From: Patel, Uday [Uday.Patel@lancashire.gov.uk]
Sent: 15 July 2013 10:14
To: planning
Cc: ENV LHS Customer Service
Subject: 3/2013/0534 - Proposed first floor extension demolition of garage and provision of turning area.
 Resubmission of 3/2013/0055 - Rose Cottage Main Street Grindleton Lancashire BB7 4QT

Planning Application Reference: 3/2013/0534

**Proposal: Proposed first floor extension demolition of garage and provision of turning area.
 Resubmission of 3/2013/0055**

Location: Rose Cottage Main Street Grindleton Lancashire BB7 4QT

Title **Proposed Site Layout**

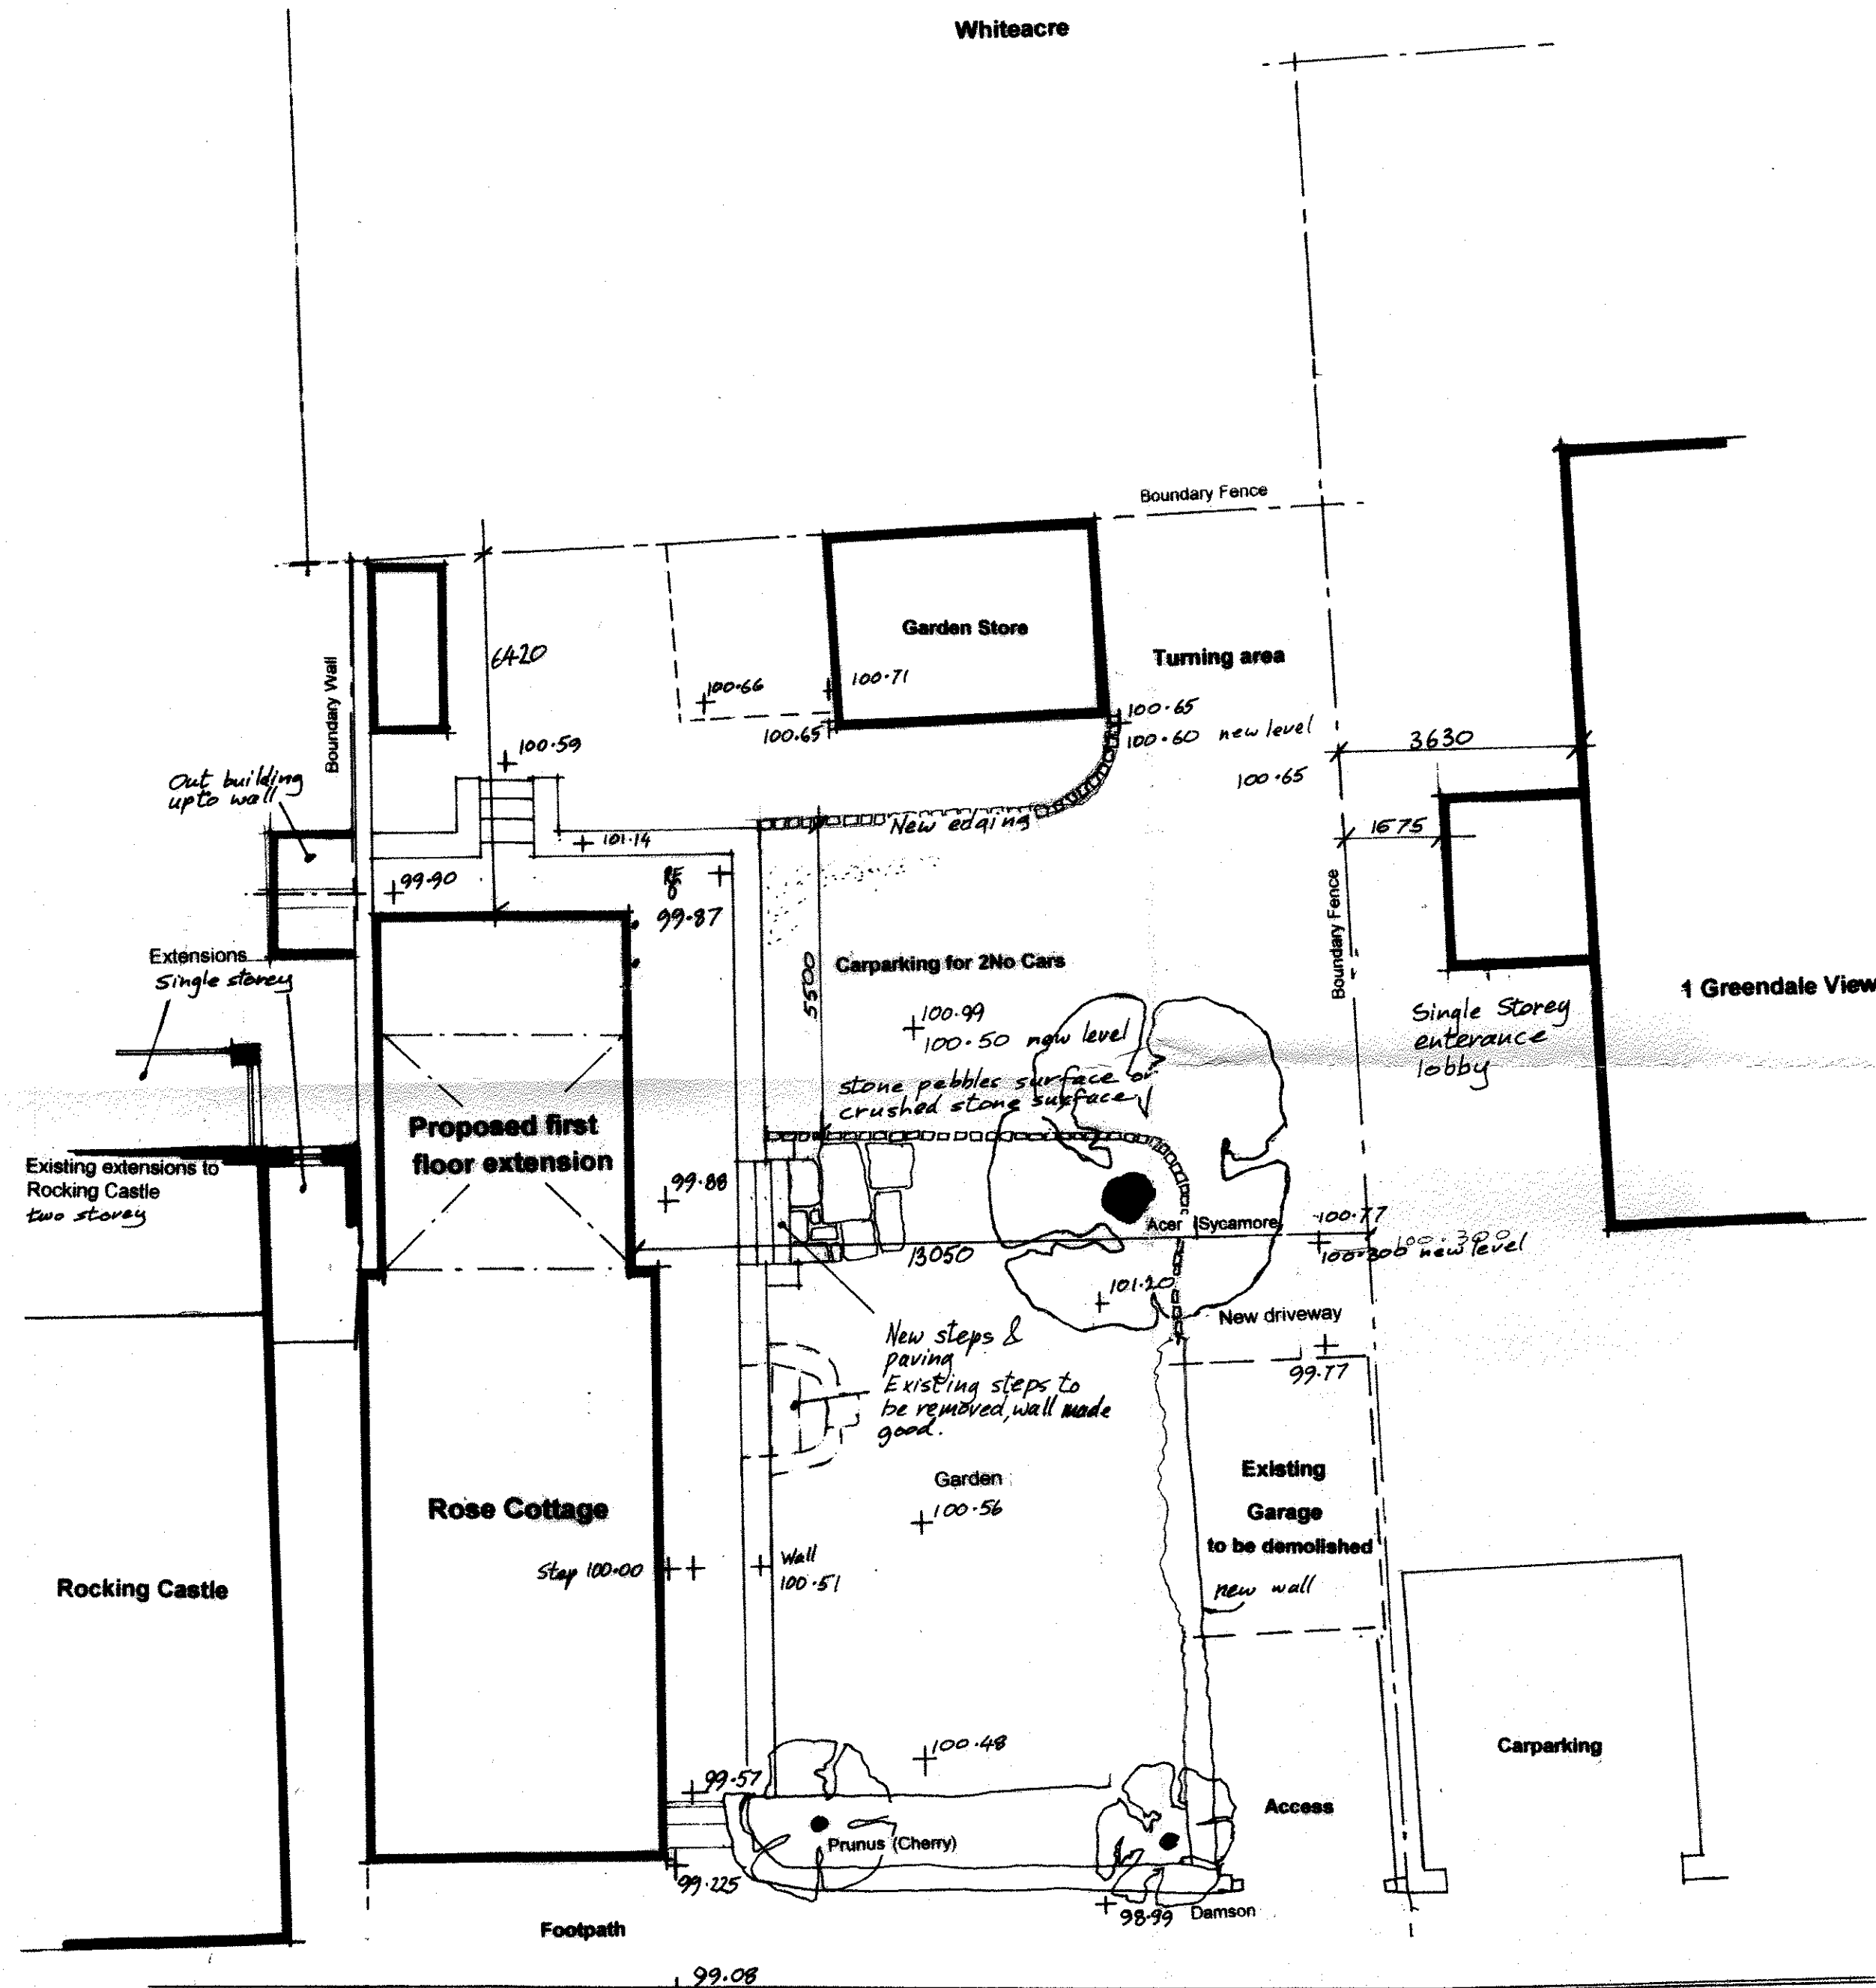
The layout of proposed development of first floor extension and demolition of garage has improved. Proposed layout indicates the turning area of the vehicles within the curtilage of the property to realise the vehicles leaving the property in forward gear position. Dropped kerbs in front of the drive way along Main Street is existing. It is believed that there is no work required on the highway in this regard.

It is noticed that there will be significant earth work required to suit the levels of the external works including drive way and turning area. Existing garage is also to be demolished. It is anticipated that construction machinery and equipment including skips and delivery vehicles may be required during the work.

There is a concern about the visibility on north side of the existing access to the property, which is blocked by the stone wall. Considering that existing drive way is currently in use and stone wall is existing, it is unlikely to have a significant effect on the highway with the movement of one additional vehicle. Although care must be taken for the safety of pedestrian and vehicles on the footway and carriage way while exiting from the property in forward gear position.
